20 August 2021

Case Number EQ/21/50720
Proposal Proposed rear extension
Site Heathgate, Furzey Lane, Beaulieu, Brockenhurst, SO42 7WB

**PROPOSED PERMITTED
 DEVELOPMENT
 EXTENSION**

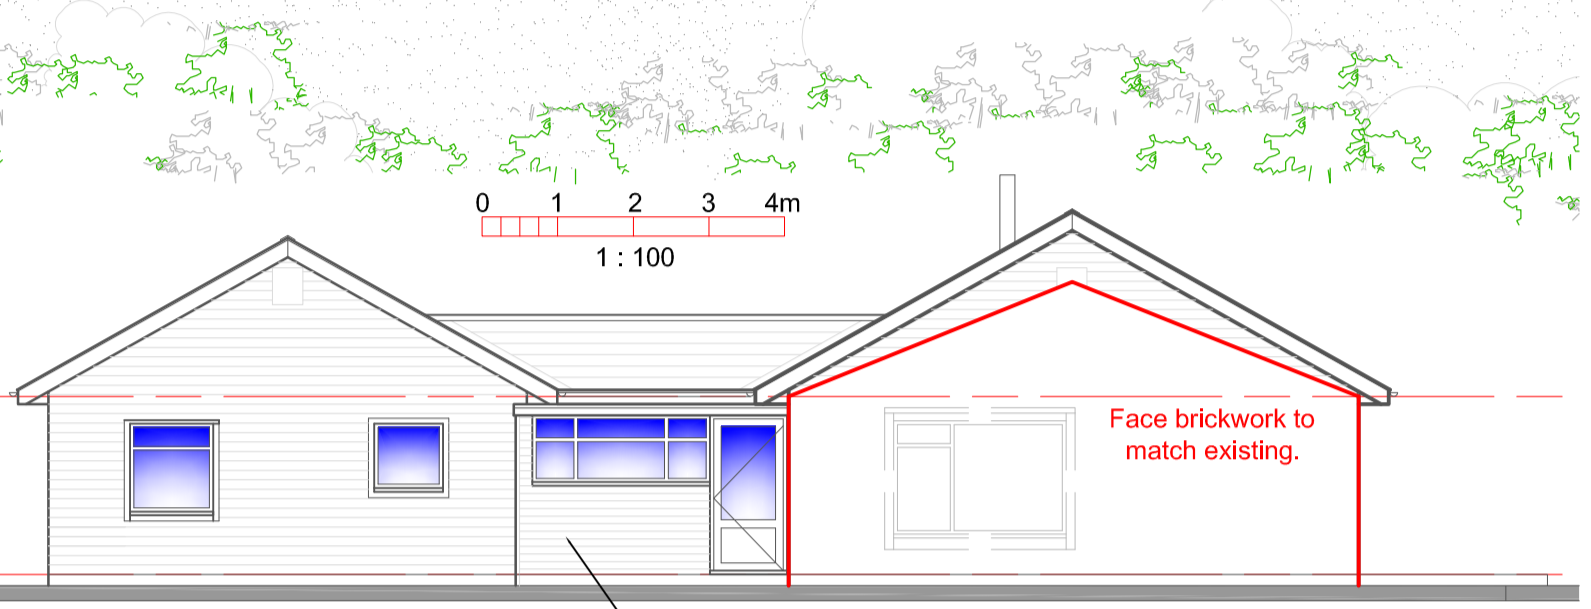
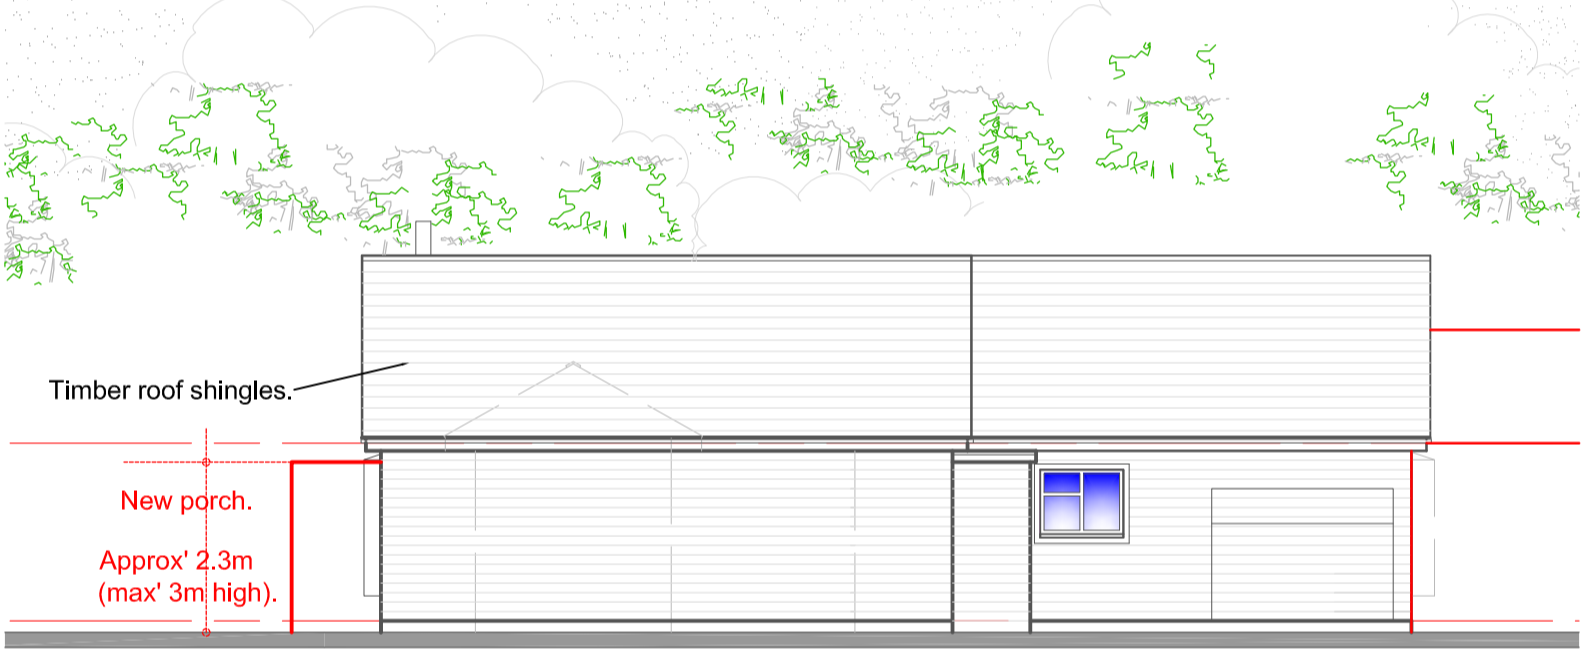
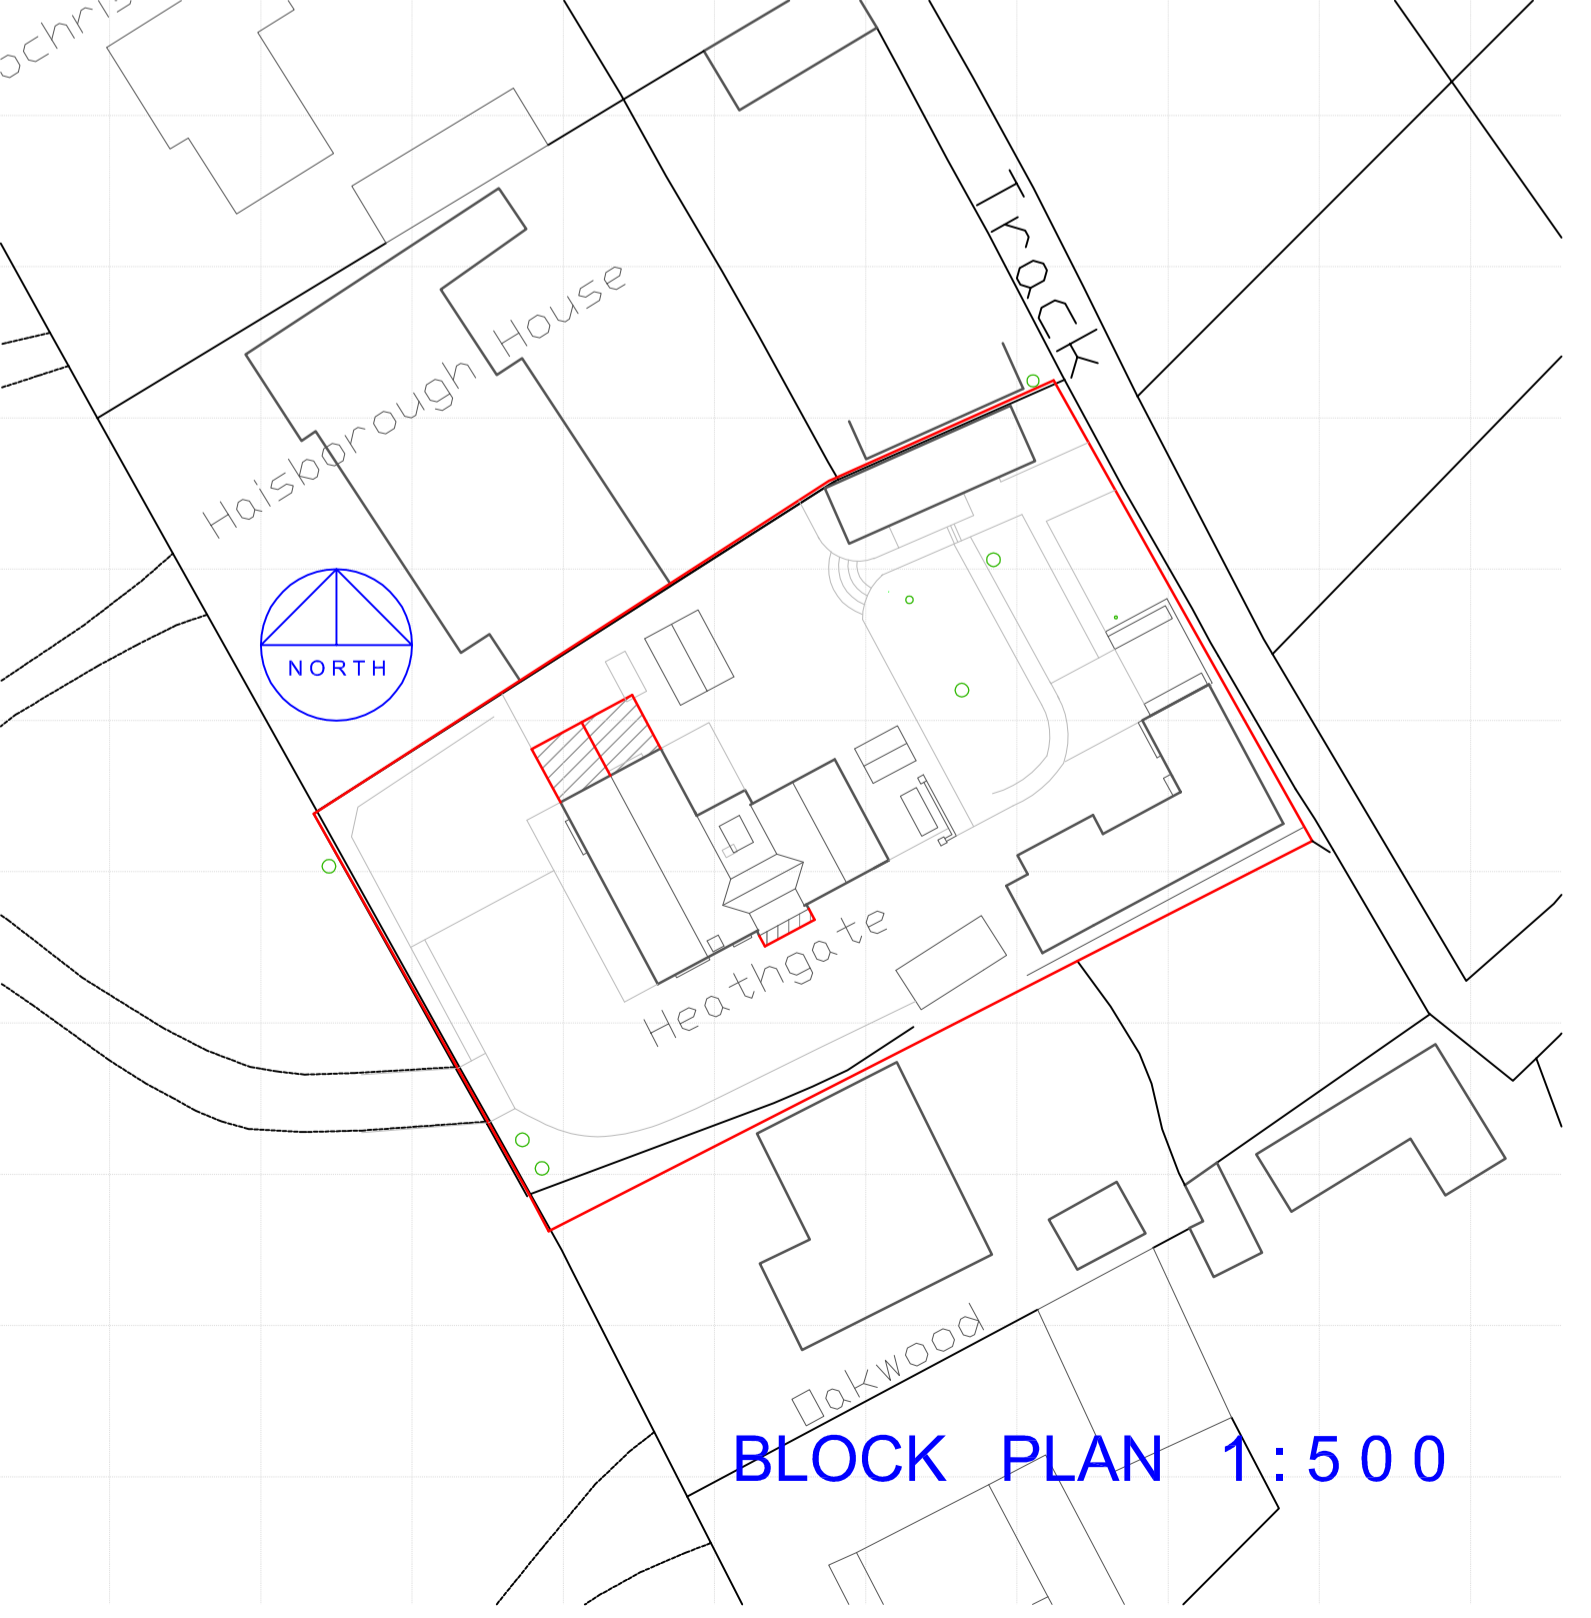
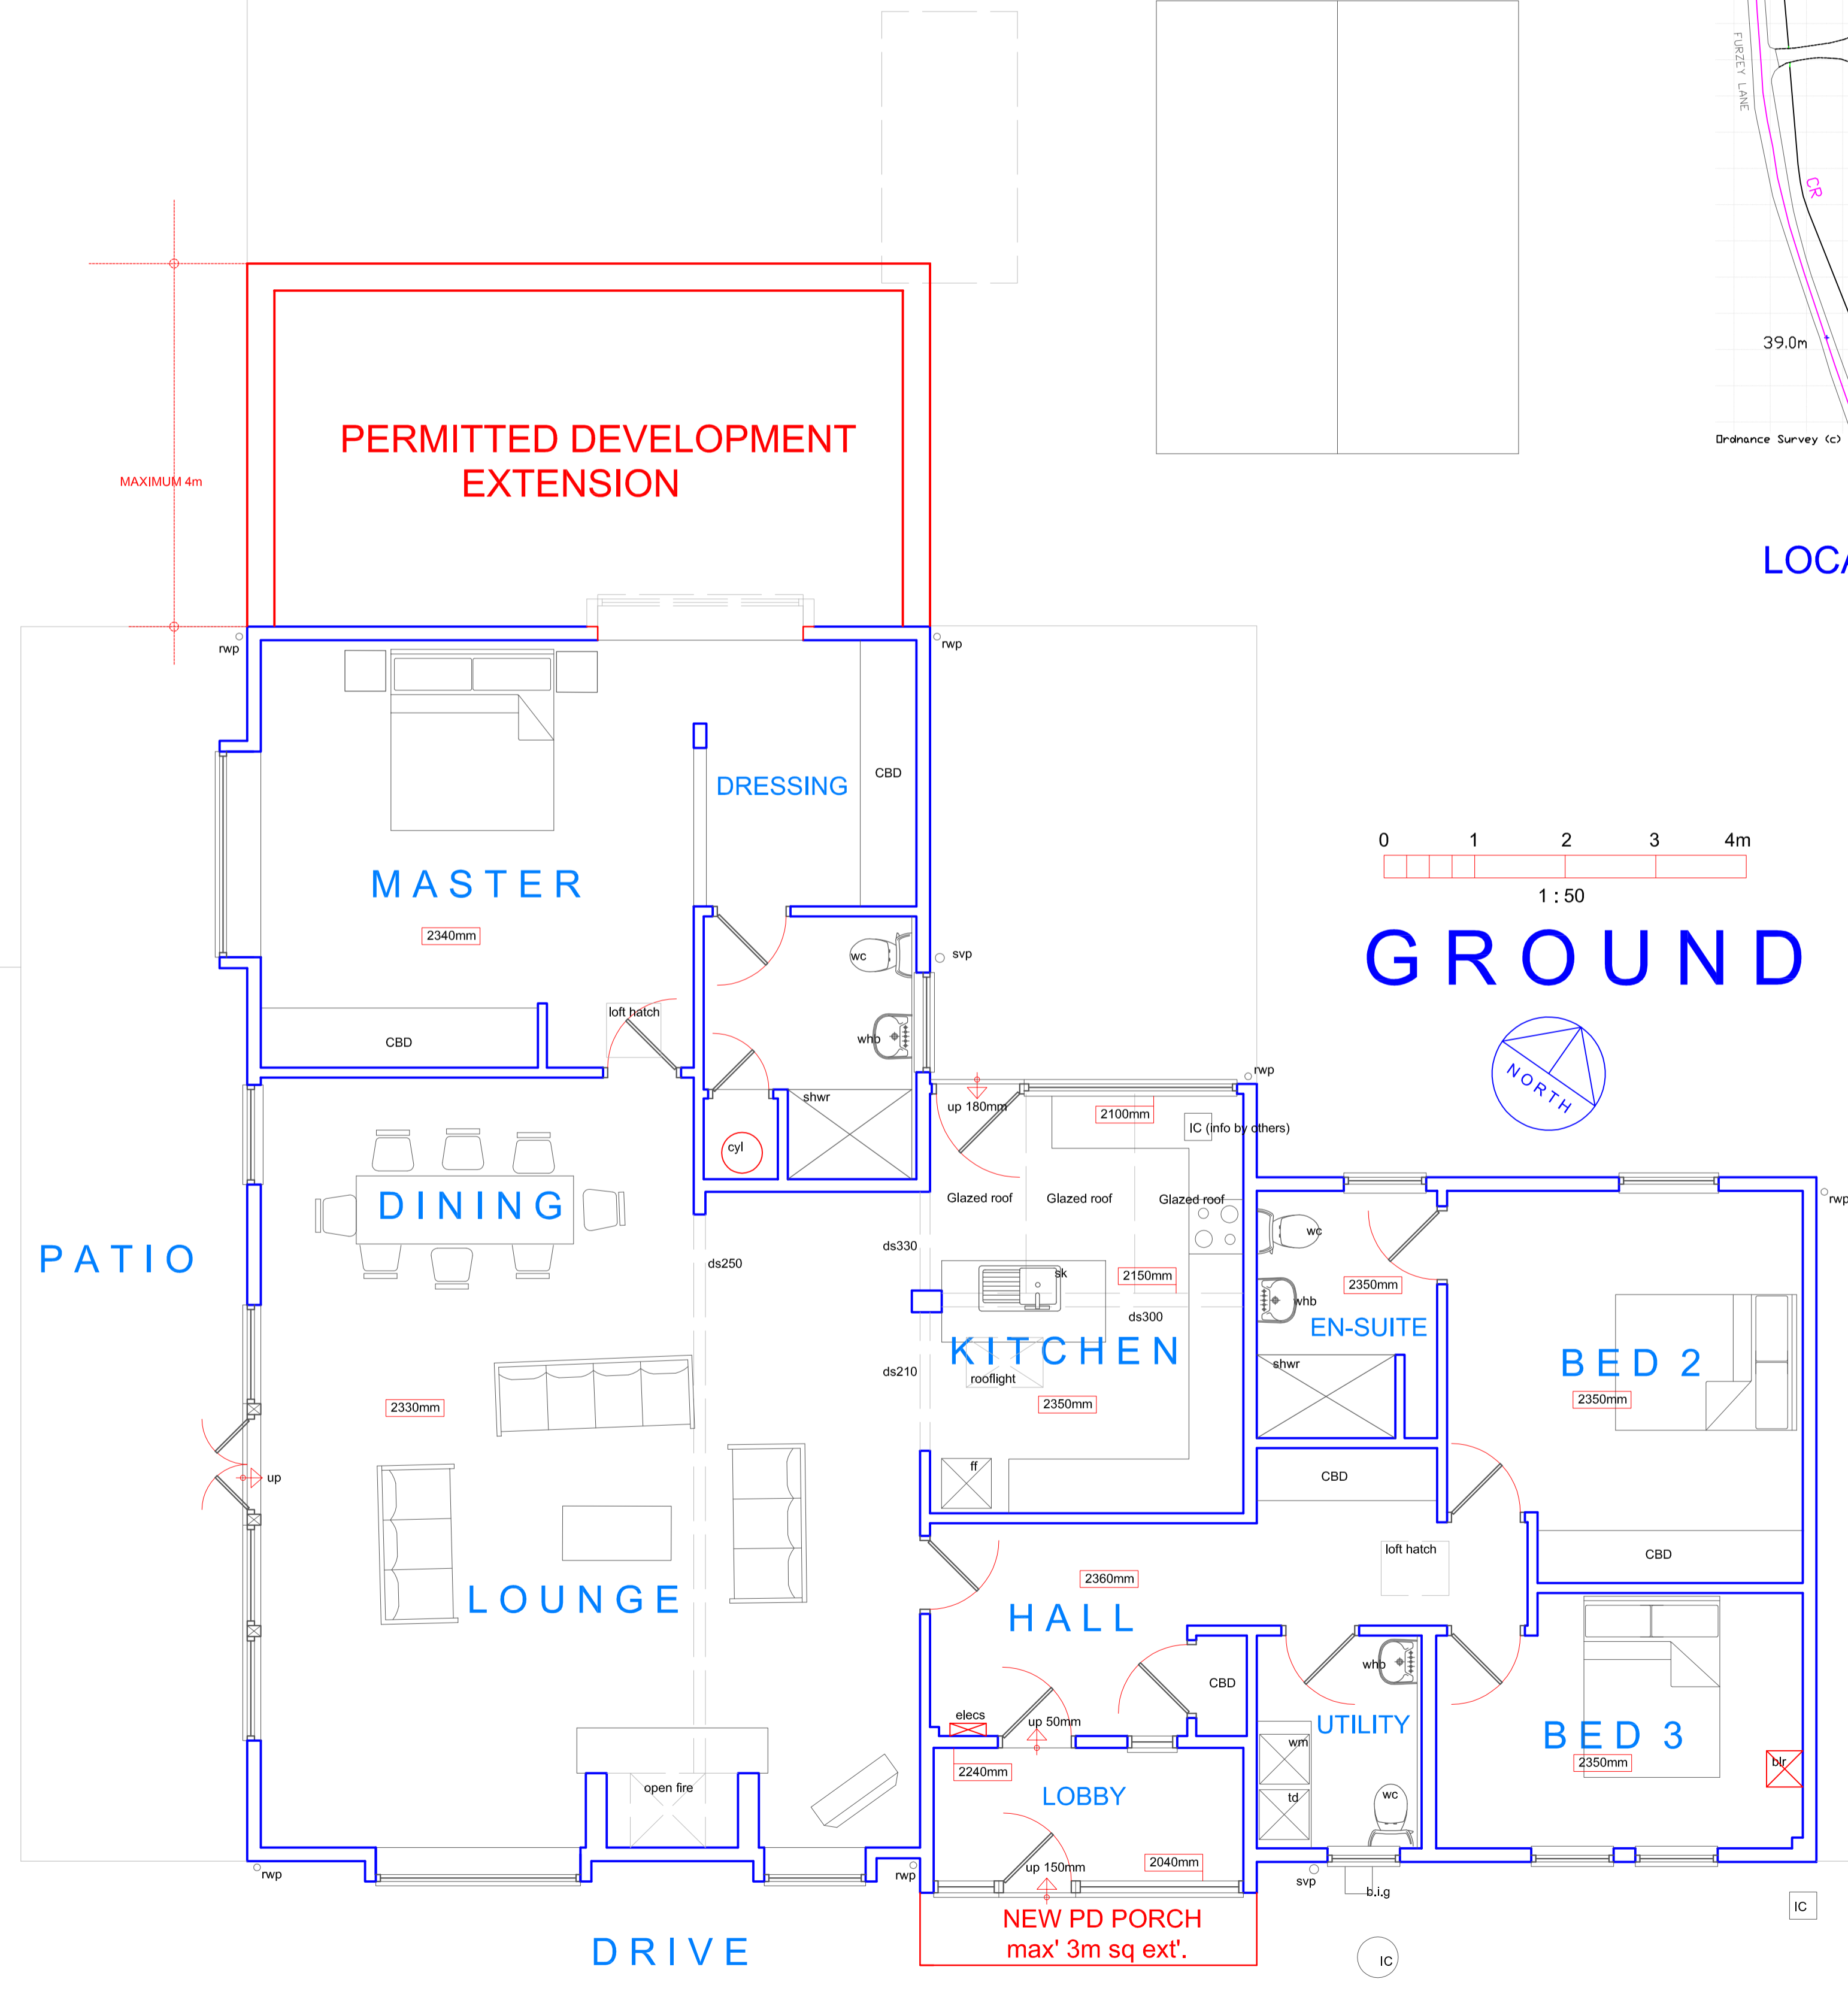
The extension would appear to comply with all measurements required by Class A of the Town and Country Planning (General Permitted Development) Order 2015 (as amended) for a new extension.

In terms of the location of the proposed development this would be opposite the original Principal elevation of the dwelling and is therefore considered to be from the original rear of the property. This elevation has an oriel window. It is my informal view this would not be a side wall elevation as it would not be a wall down to the ground. It is my view the extension would be considered permitted development.
